**SUBJECT: SF-18-025 – Ellicott Town Center Filing No. 1
Response to County PCD-Engineering Review Comments**

In conjunction with our final plat re-submittal, this letter provides responses to the review comments detailed in the Memorandum from PCD-Engineering dated March 4, 2020. These review comments are specifically addressed as follows (**Applicant responses are annotated in bold / red / parenthesis following each County comment**):

PCD Memorandum dated March 4, 2020

TEMPORARY POND C2.8 PLAN

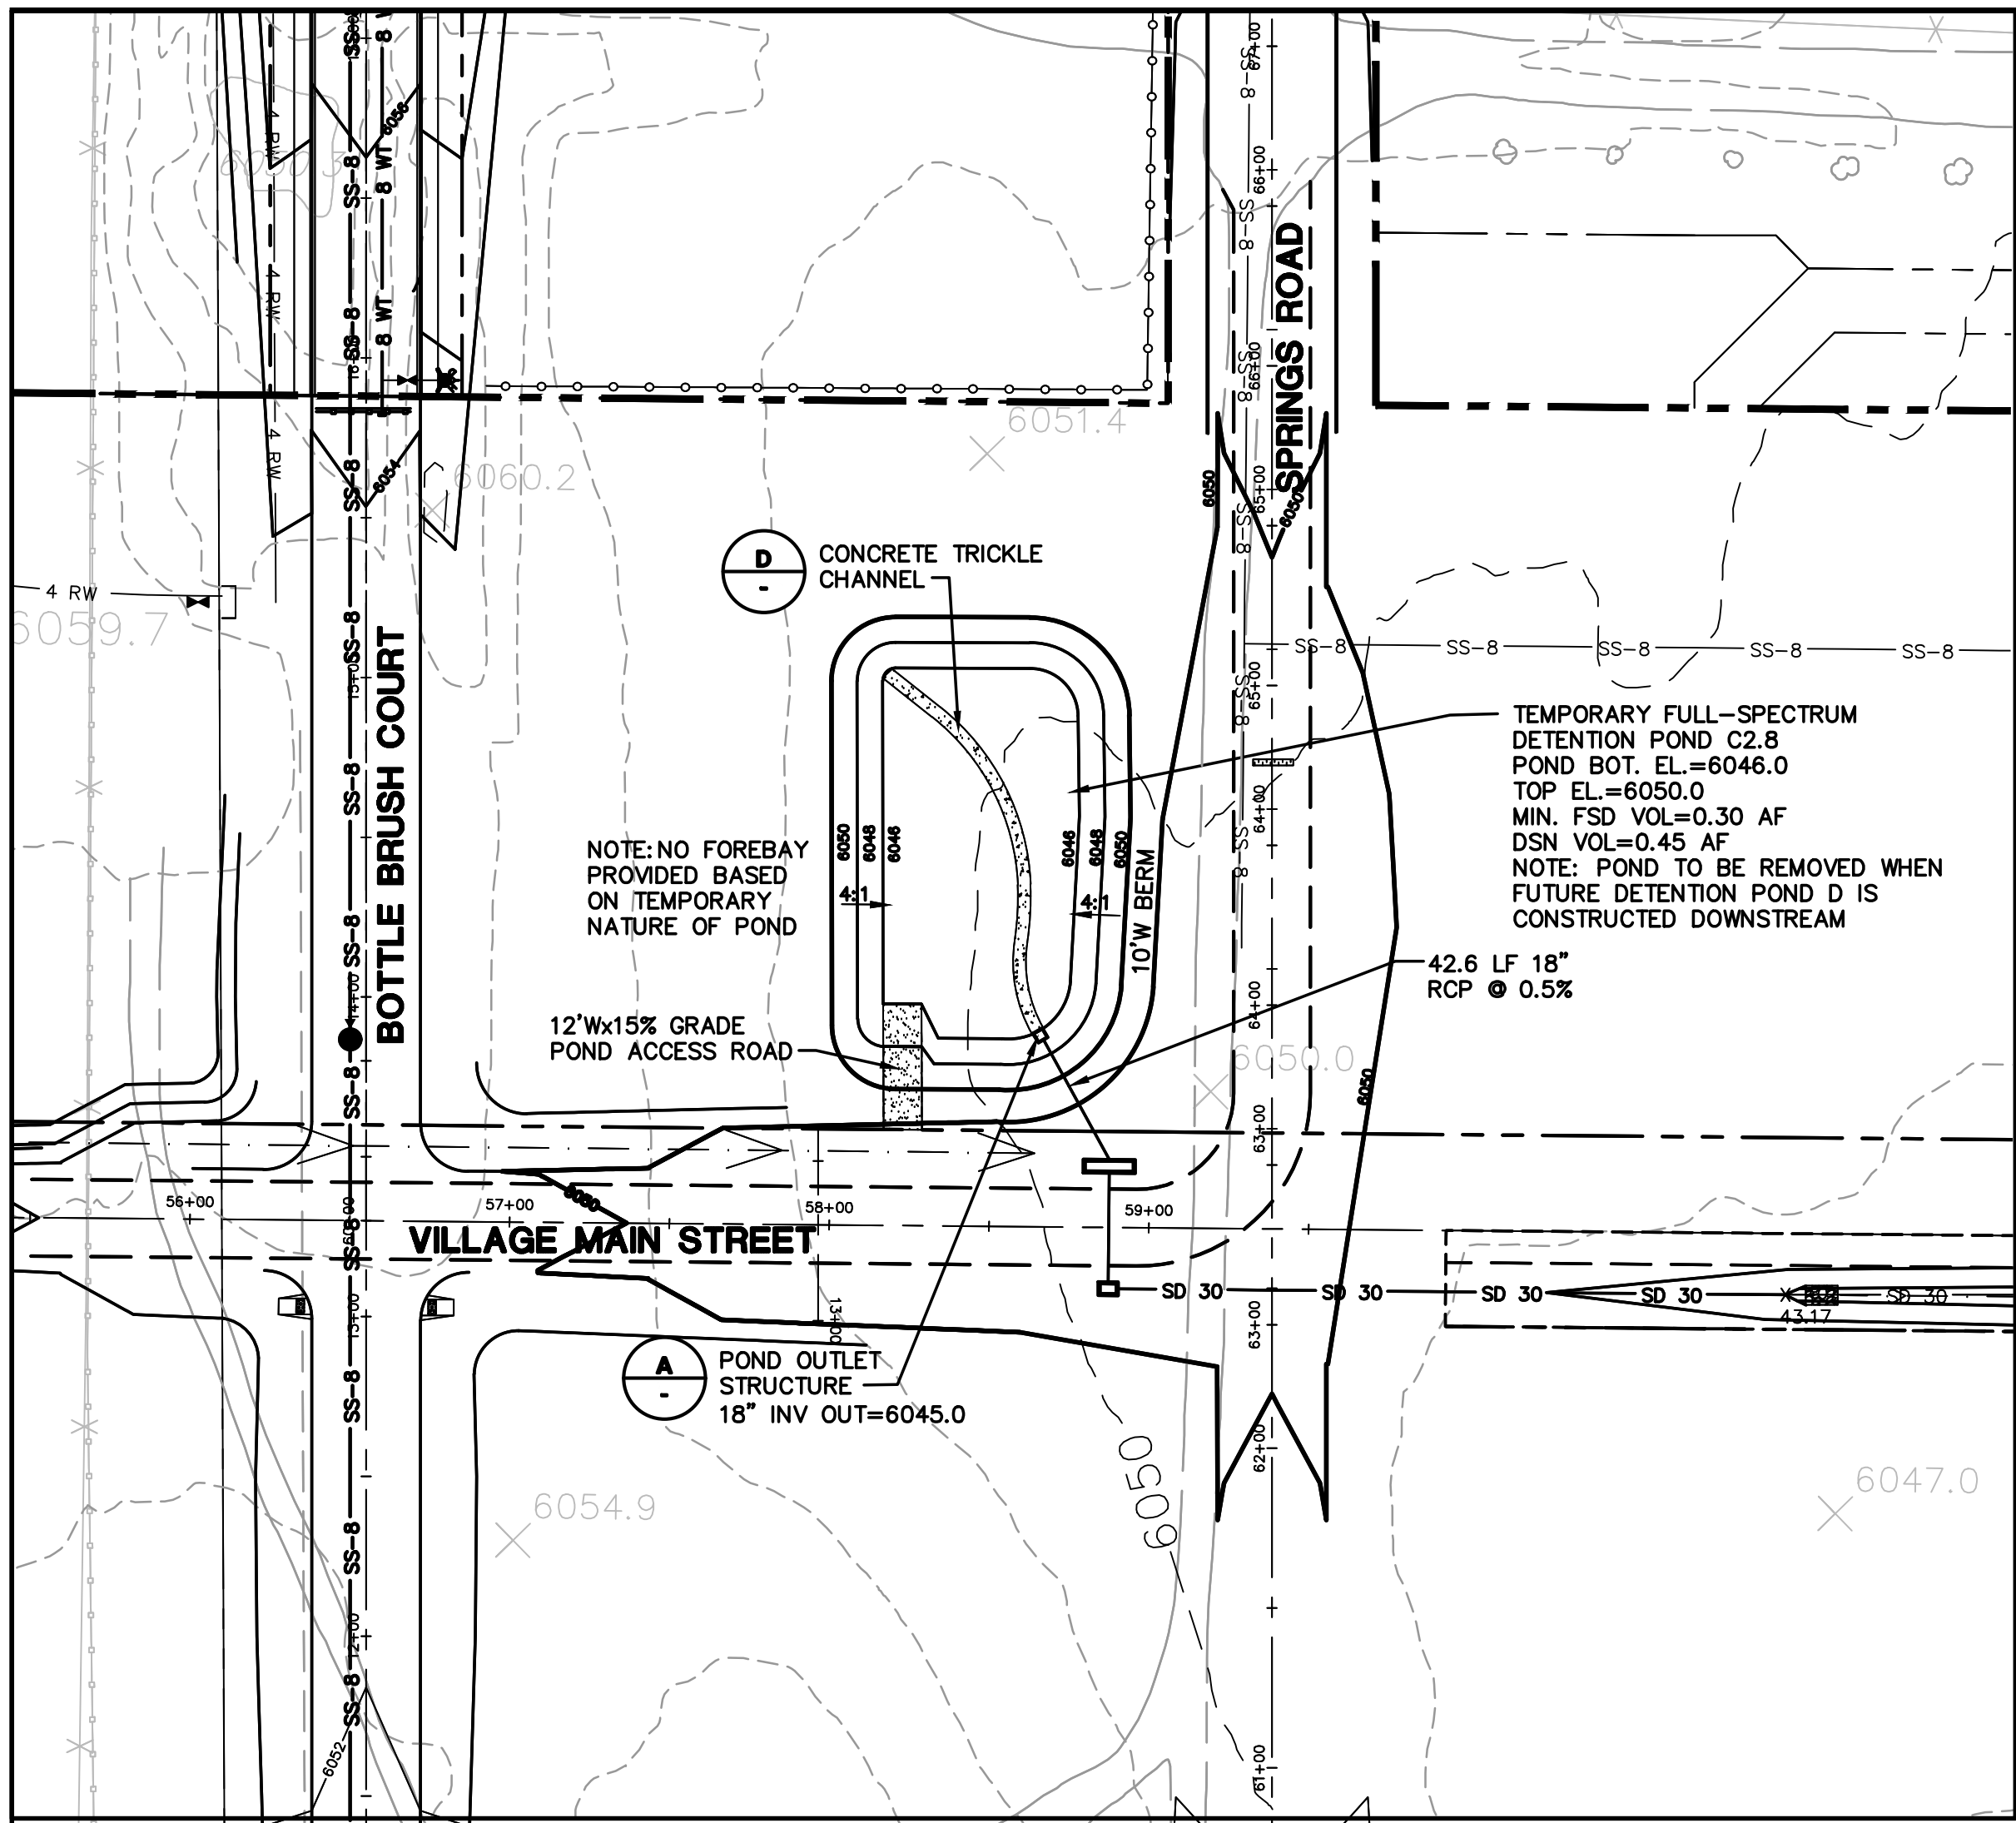
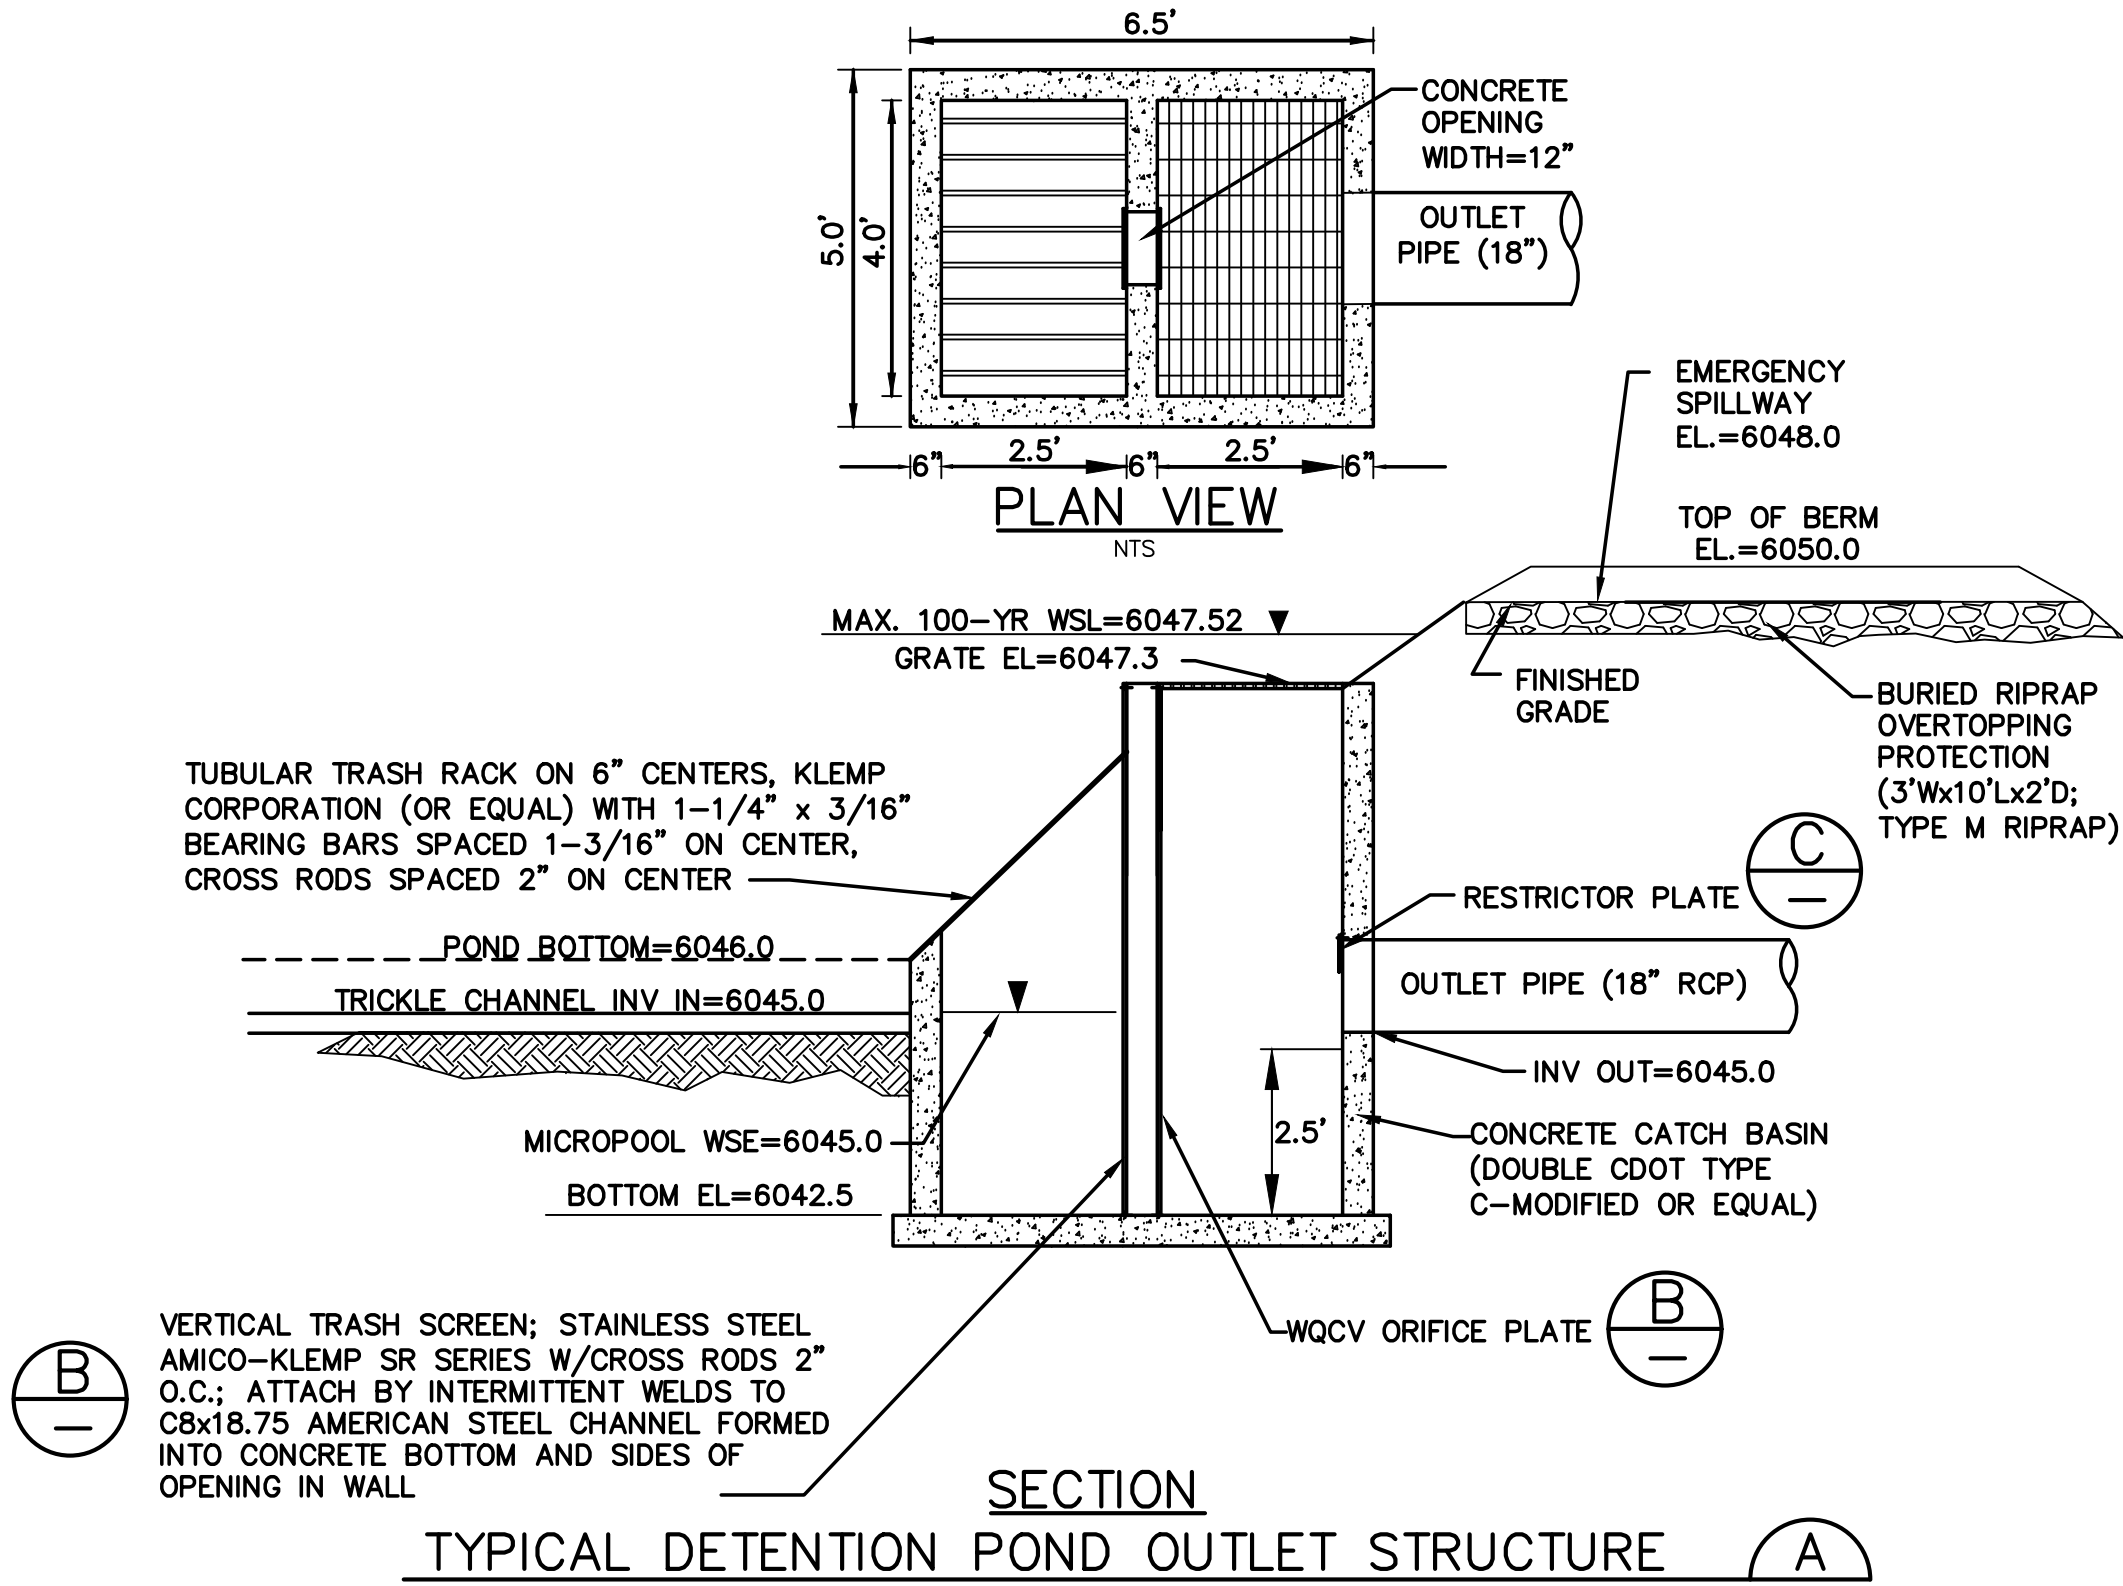
3. Show and label maintenance access roads on the plans. Unresolved; see redlines. **Partially resolved; additional detail is needed at the southwest corner of Pond C2.8. (Sh. C1.6 has been revised)**

TEMPORARY POND C2.8 PLAN

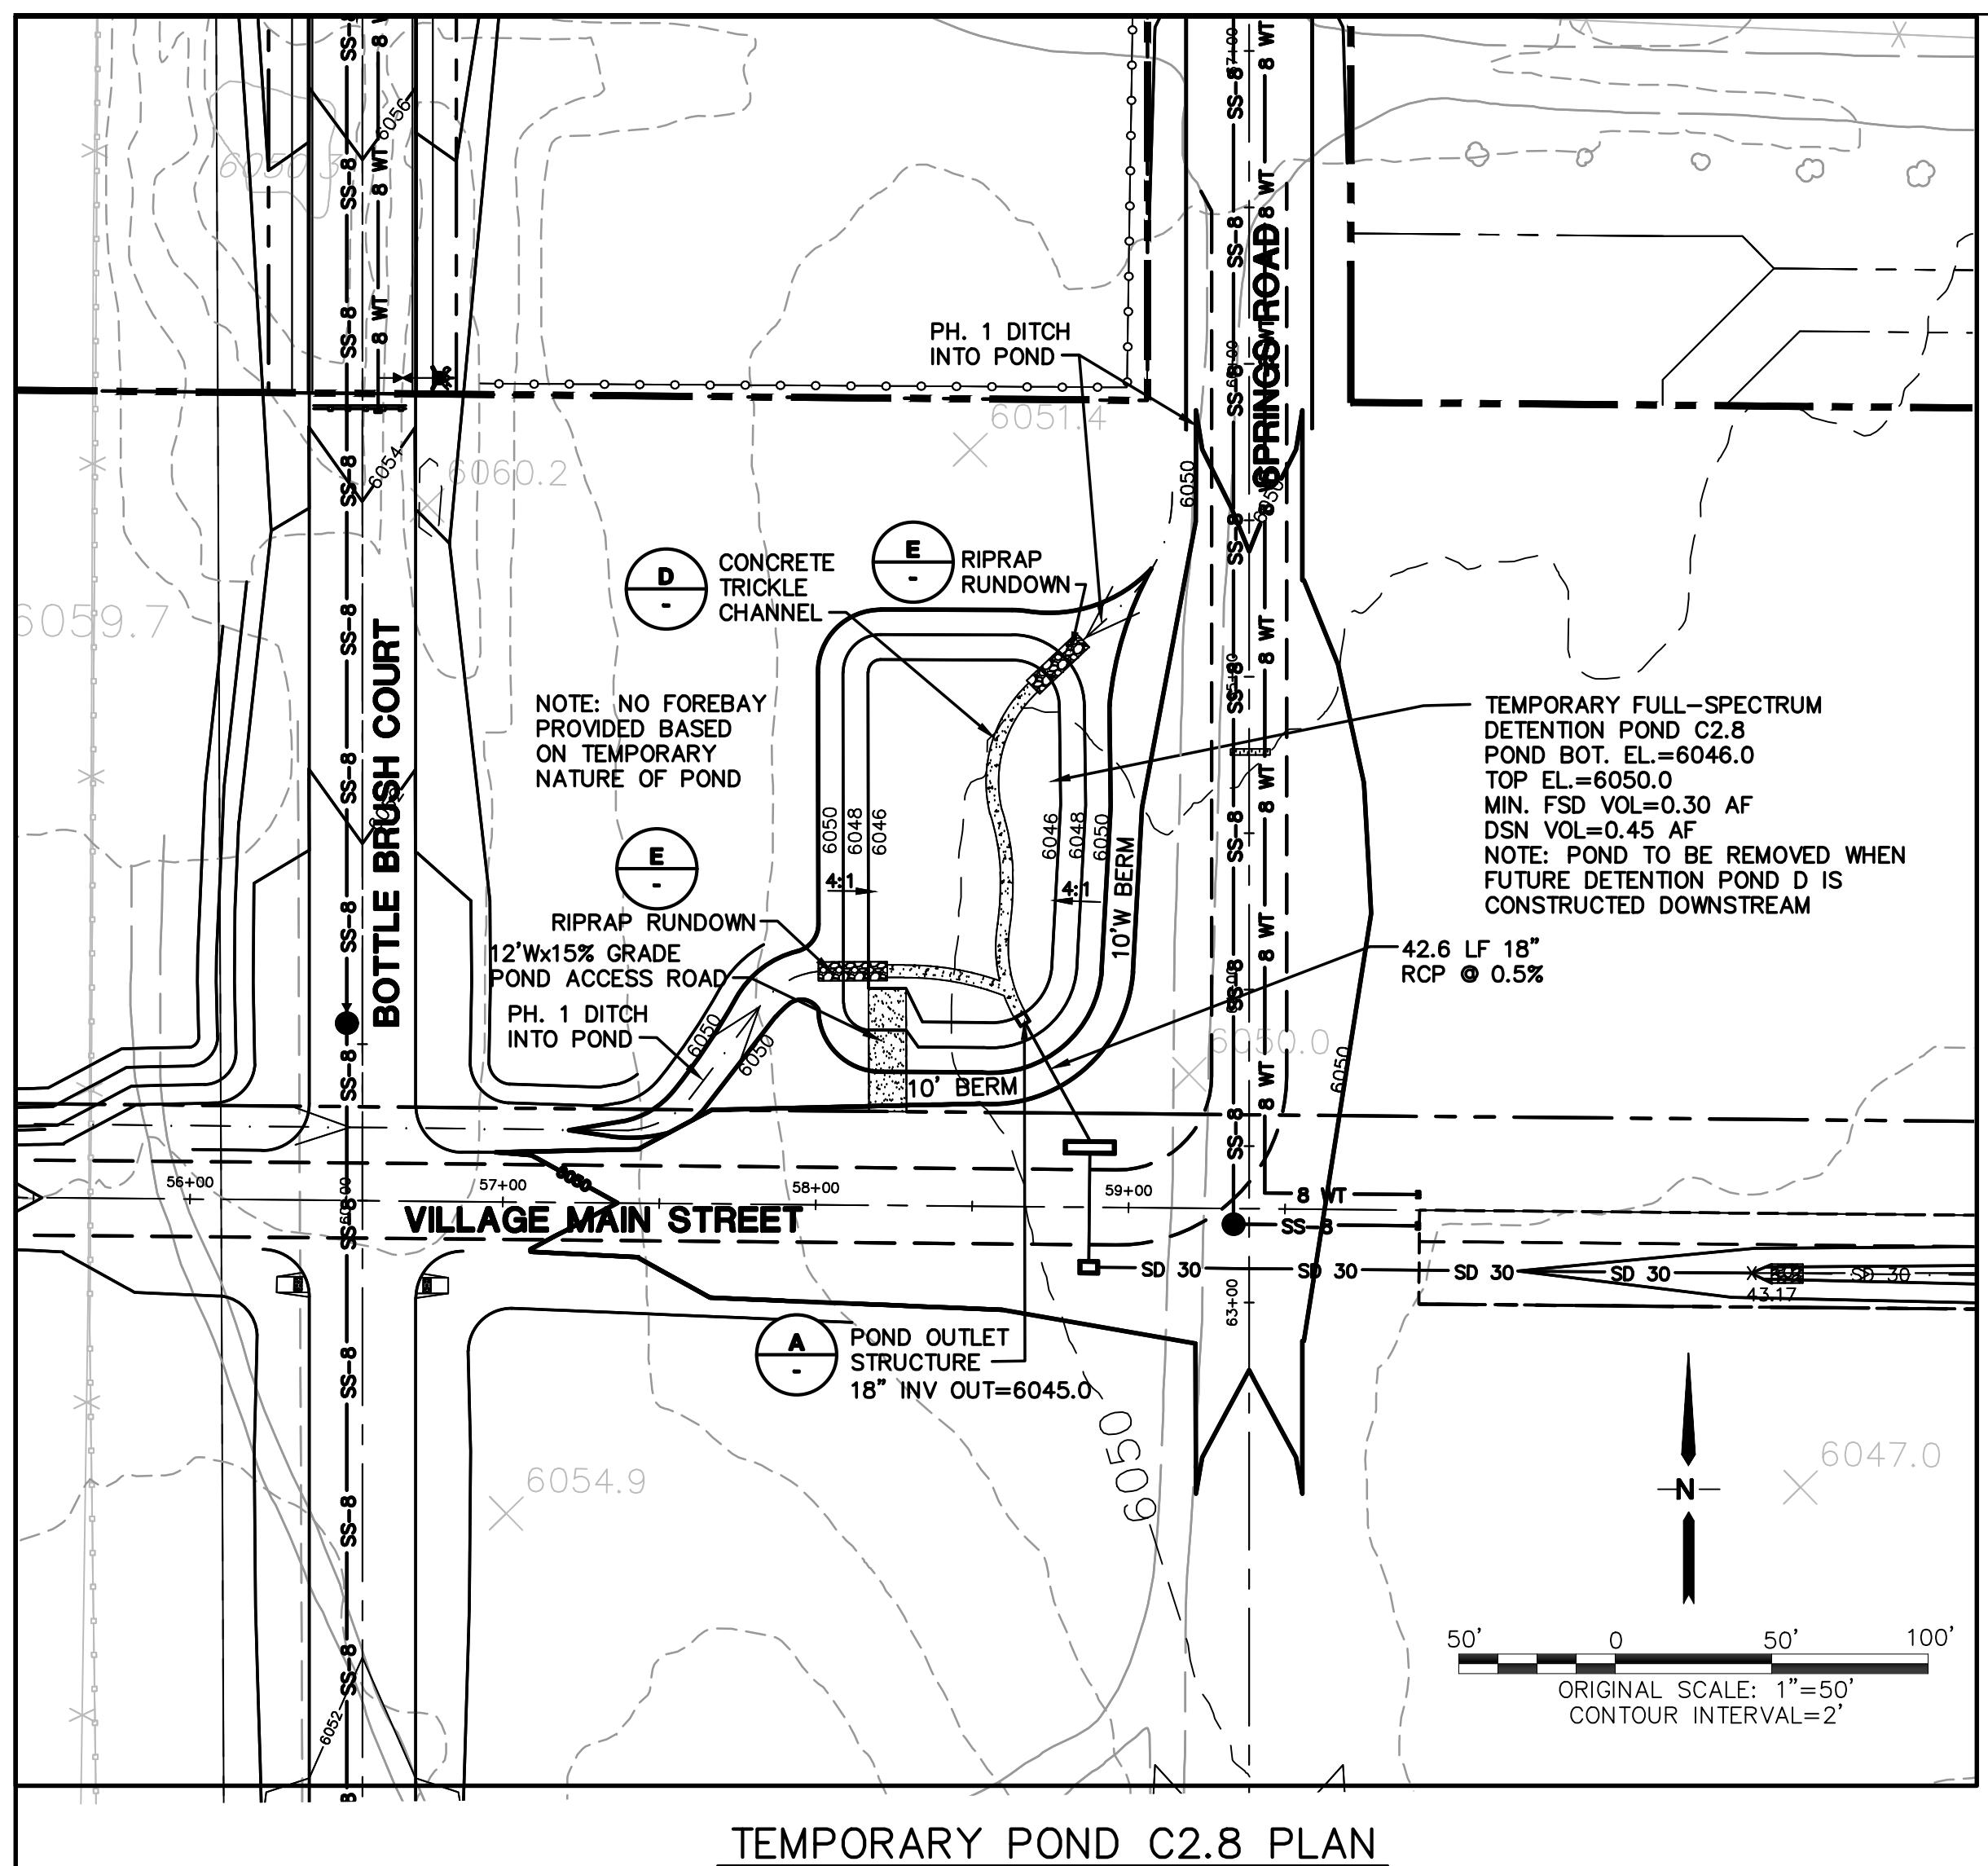
7. *Resolved.*
8. Provide approved CDOT plans for PCD file. *Provide when available.*
9. **Note: temporary pond C2.8 design may require revisions depending on approval of deviation request. Staff believes approval of the deviation will be more likely if the pond is provided with some form of trickle channel(s). (Concrete trickle channel has been added as requested)**
